# Drexel, Barrell & Co.

June 26, 2024

**RE: Comment Response Letter for:  
Church of Jesus Christ of Latter-Day Saints (LDS)  
PPR2419: LDS Church Parking Lot at Hwy 105 Site Development Plan  
Address: 950 CO-105, Monument, CO 80132**

**INITIAL GRADING
 & EROSION
 CONTROL PLAN**

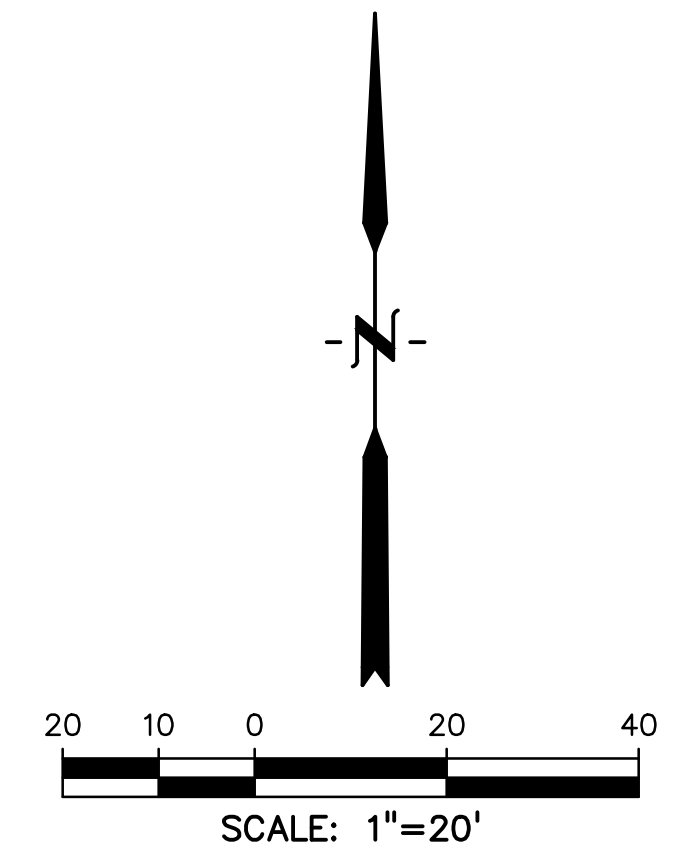
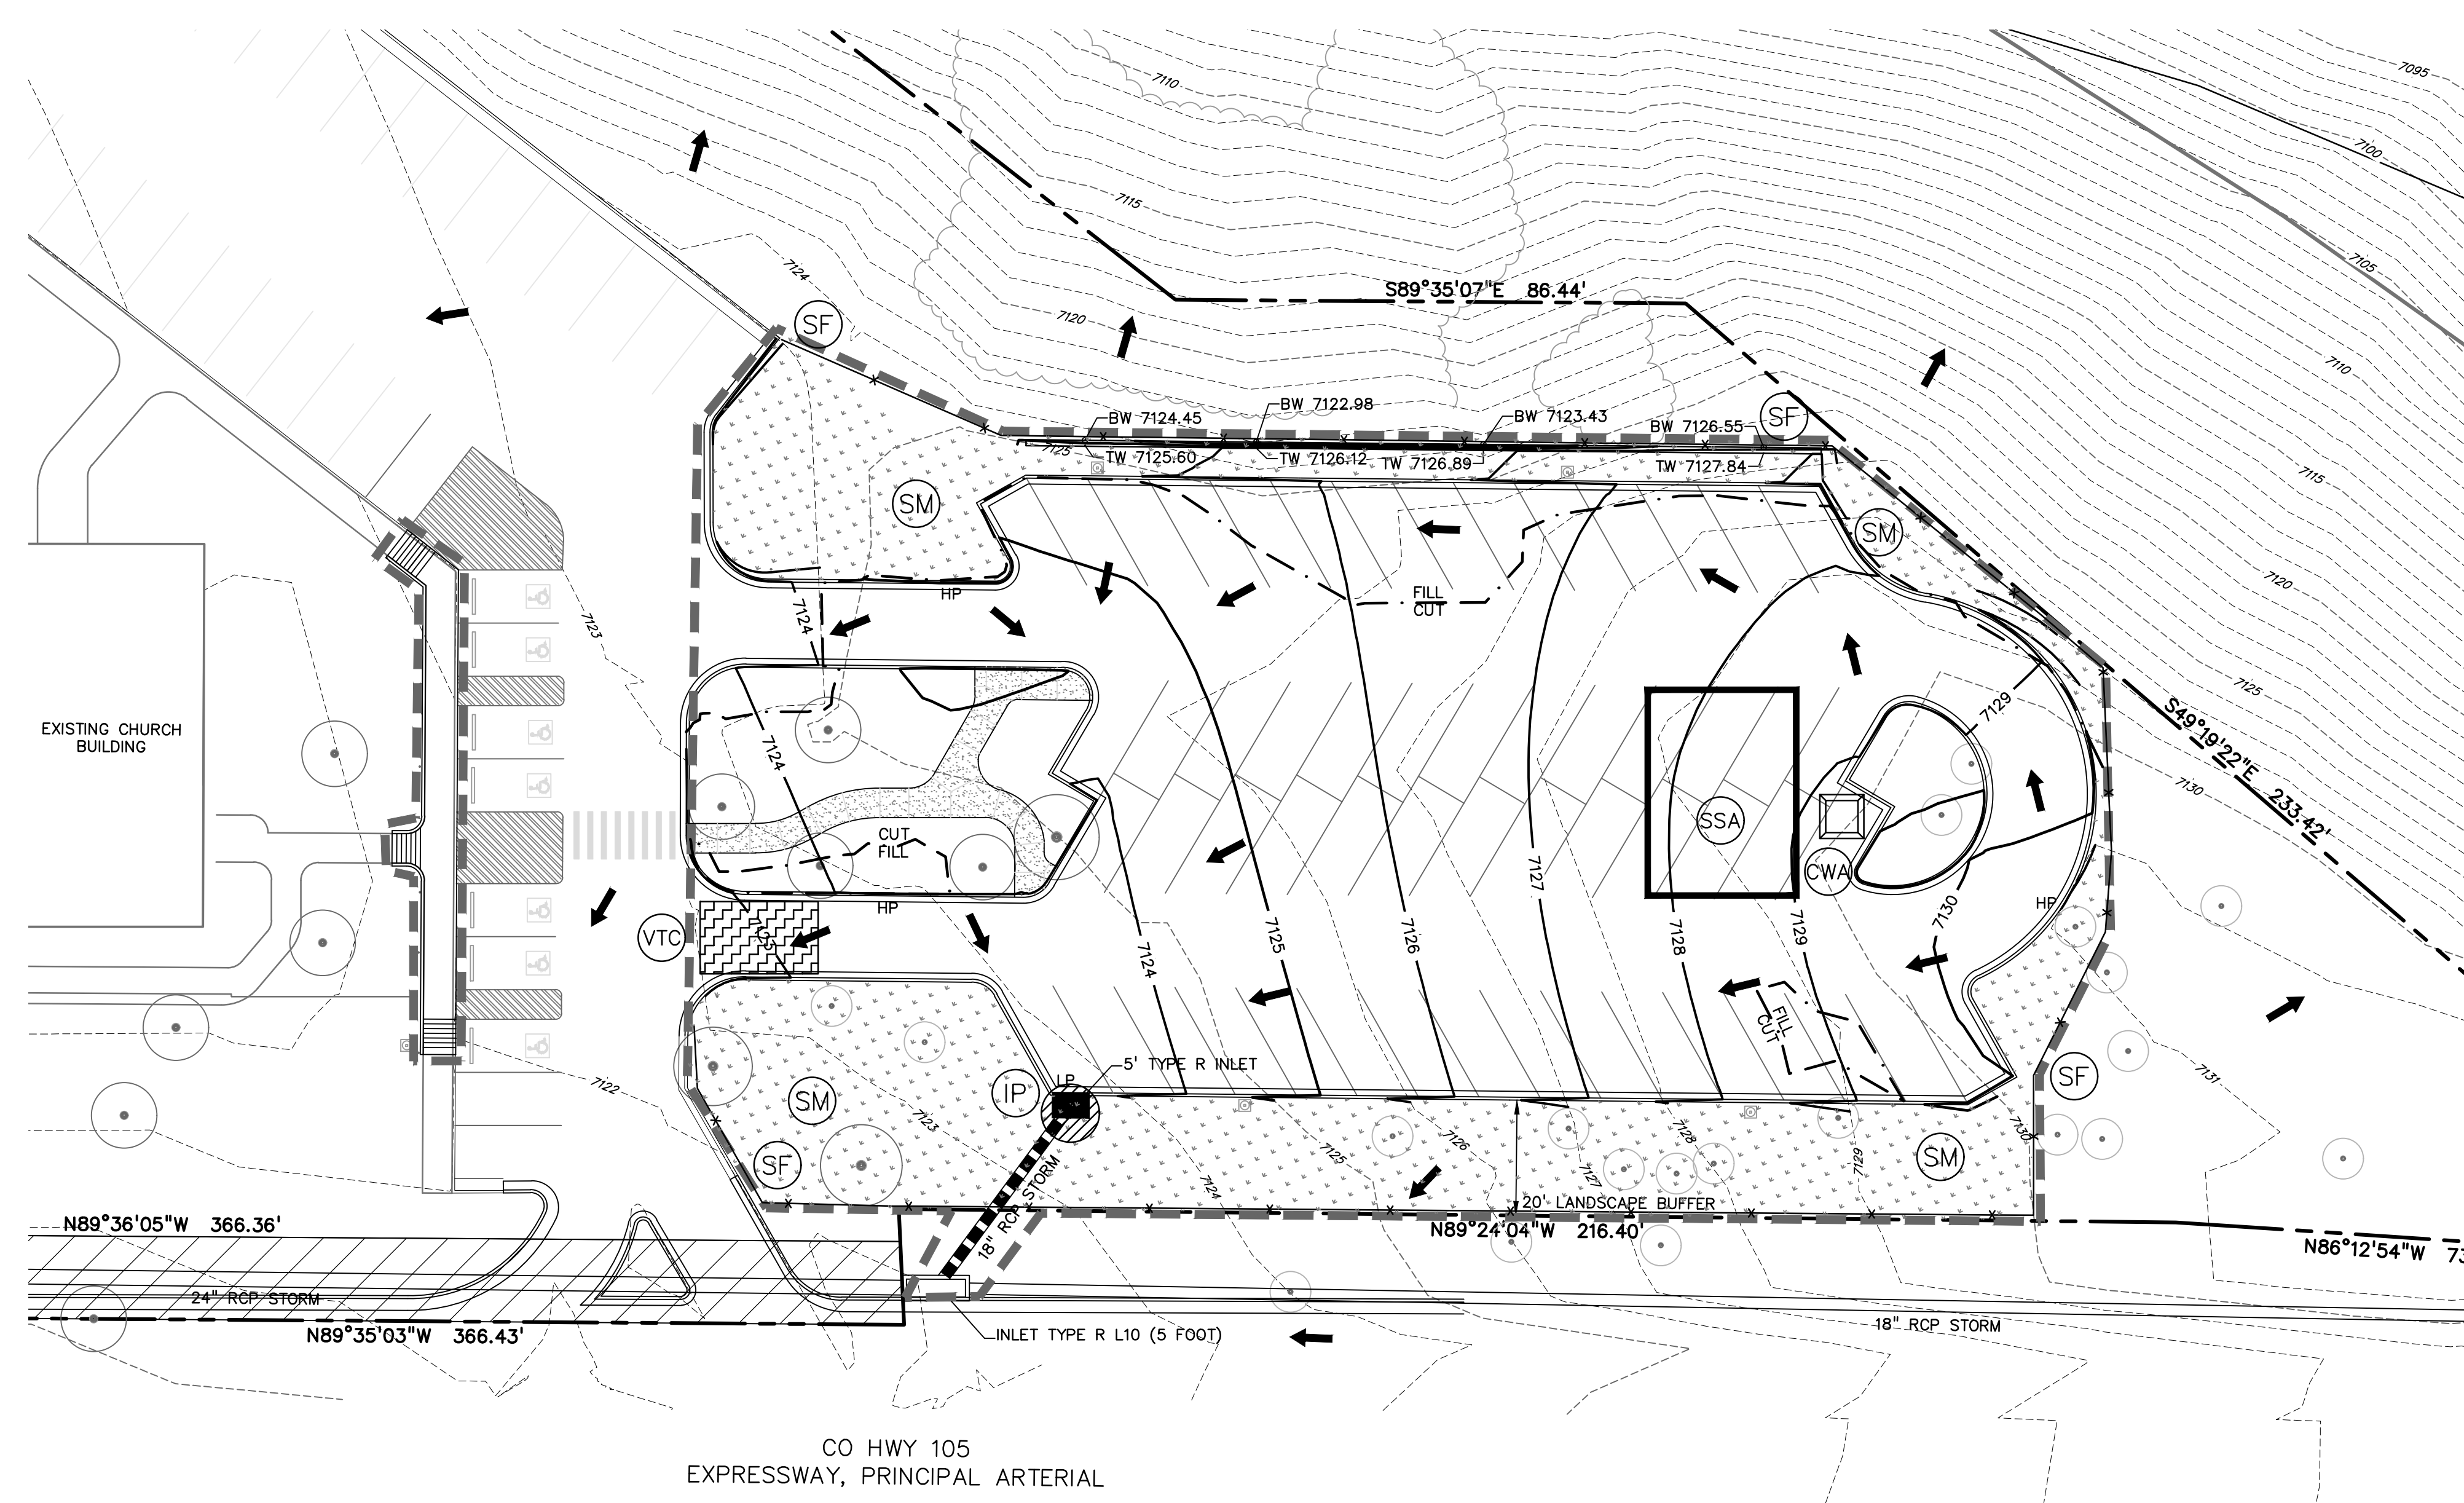
Please provide CD sheet for new 18in RCP from parking lot that will connect into ROW.

Noted, see details below and attached.
